Online Comment

Application H16-1224-25
Location 43 Cowbit Road Spalding Lincolnshire PE11 2RQ
Proposal Proposed Detached Garage with Home Gym/Games Room Above

Name Spalding & District Civic Society
Address Spalding

PROPOSED ELEVATIONS.

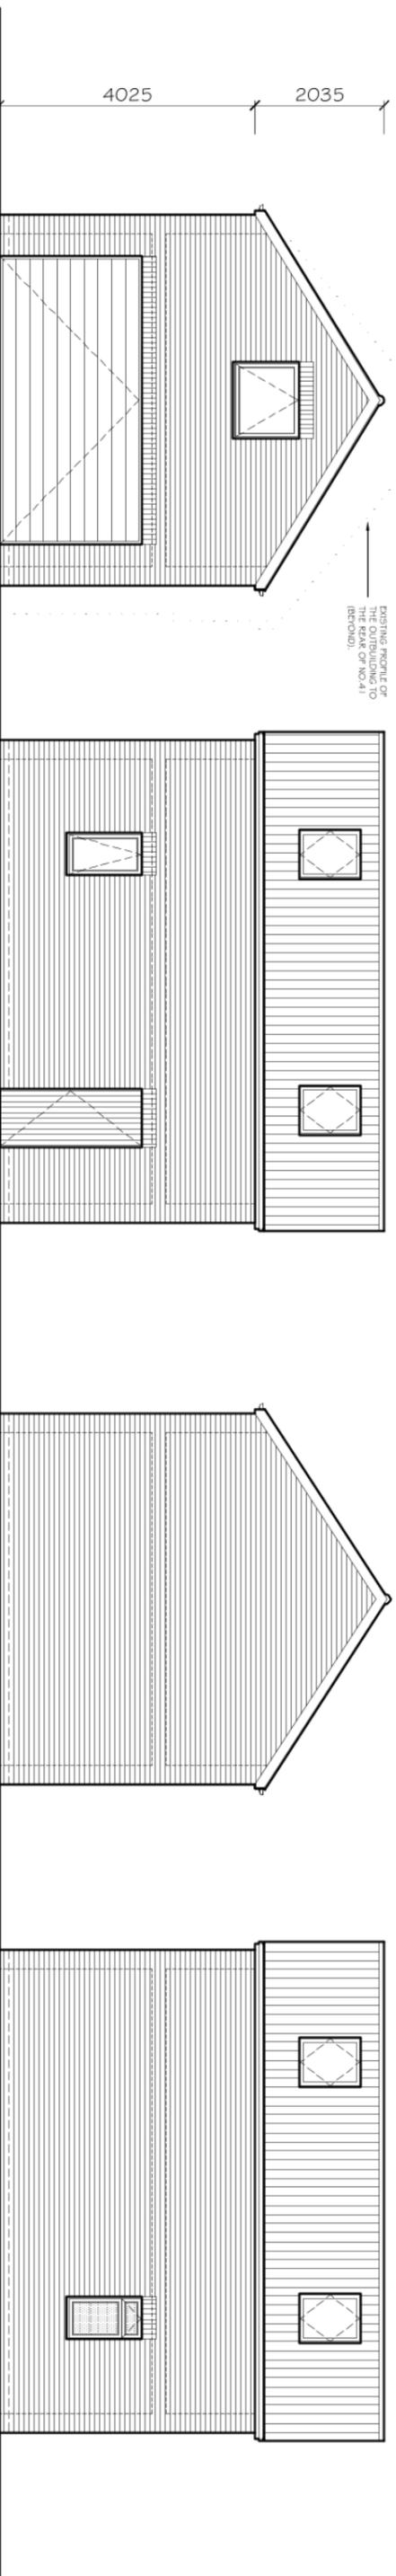
- 1 The total height should be no more than the adjacent building on the property behind.
- 2 There should be a restriction on the gym being for private use only and also a noise restriction in consideration of the Neighboring properties
